CITY OF ALBUQUERQUE

October 6, 2017

RE: 6th and Haines Redevelopment
Conceptual Grading and Drainage Plan
Stamp Date: 10/5/17
Hydrology File: H14D108

SHEET NUMBER  
**SDP-3.2**  
SHEET 4 OF 10

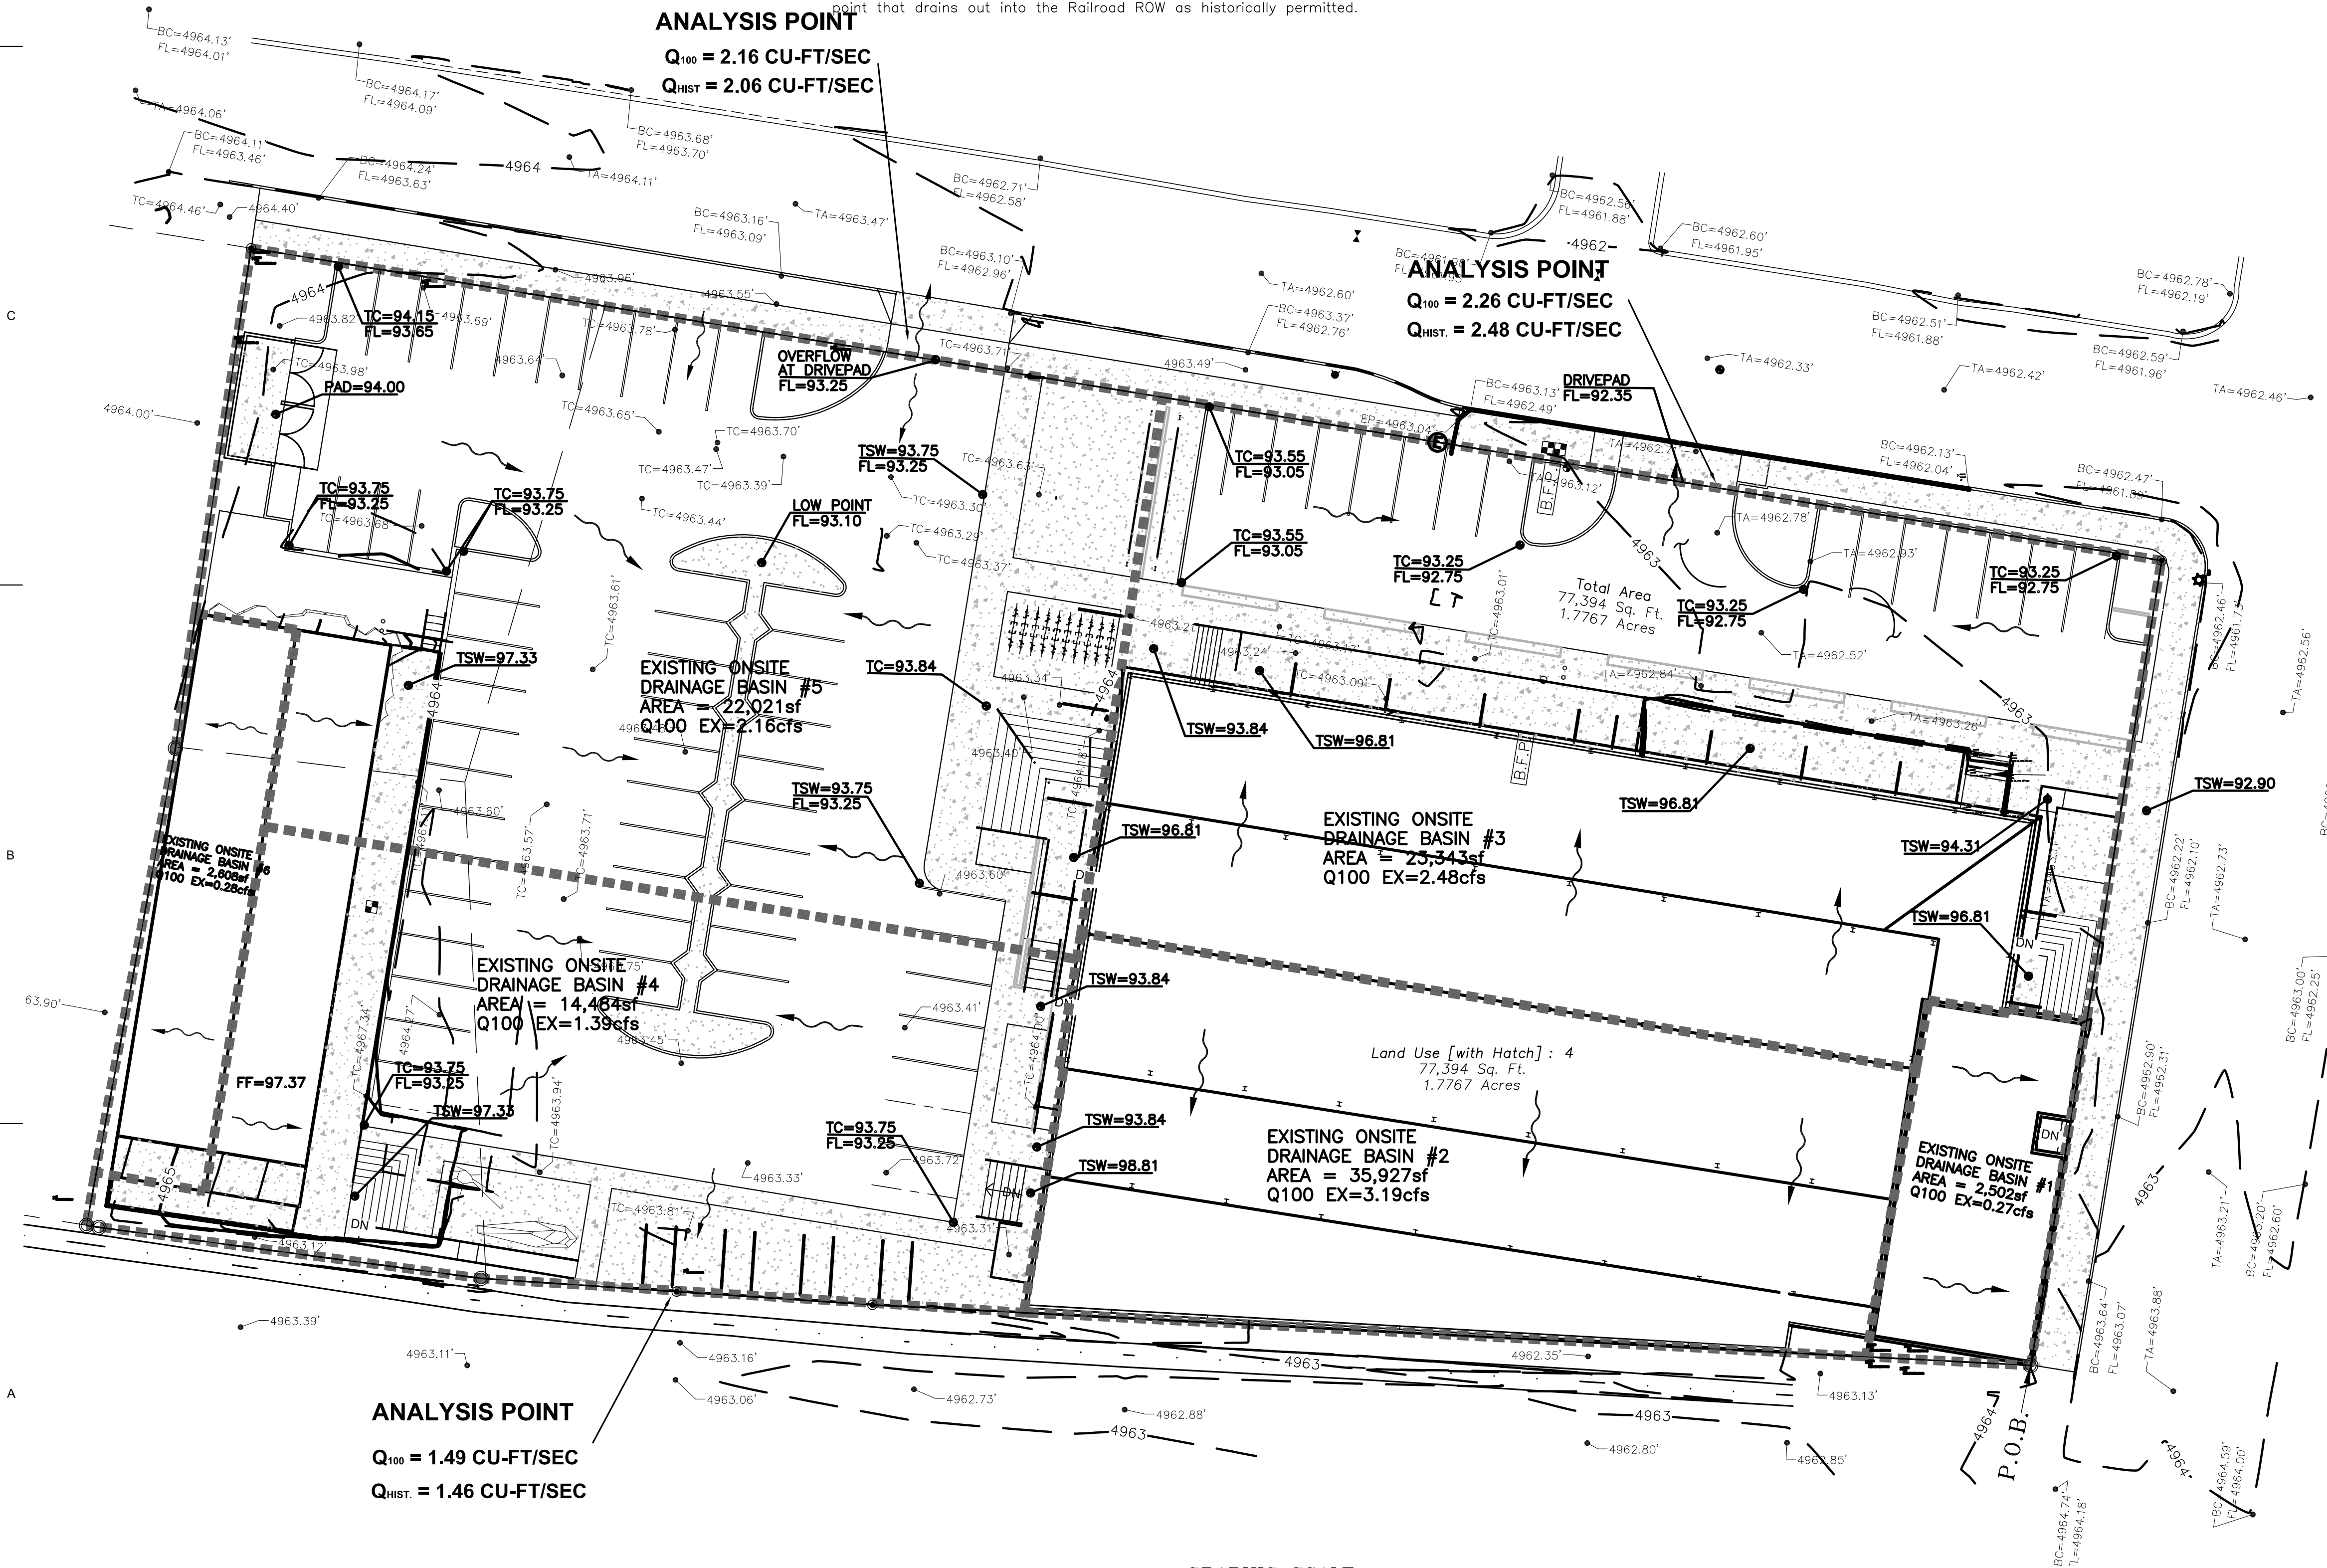
- On Sheets SDP-3.2, please call change the Basins to "Proposed" from "Existing".
- On Sheets SDP-3.2, please add the finished floor elevation to the main building.
- Please review the Proposed 100 year discharge. I checked Pro 4 and came up with 1.38 cfs instead of your 1.49 cfs.
- Not all basins need a first flush pond. Only Basin Pro 5 needs one since the impervious area increased.
- Please add a curb cut or cuts to allow runoff to enter the first flush pond within the depressed landscape areas.
- Please show the weir calculations for the proposed curb cut or cuts.
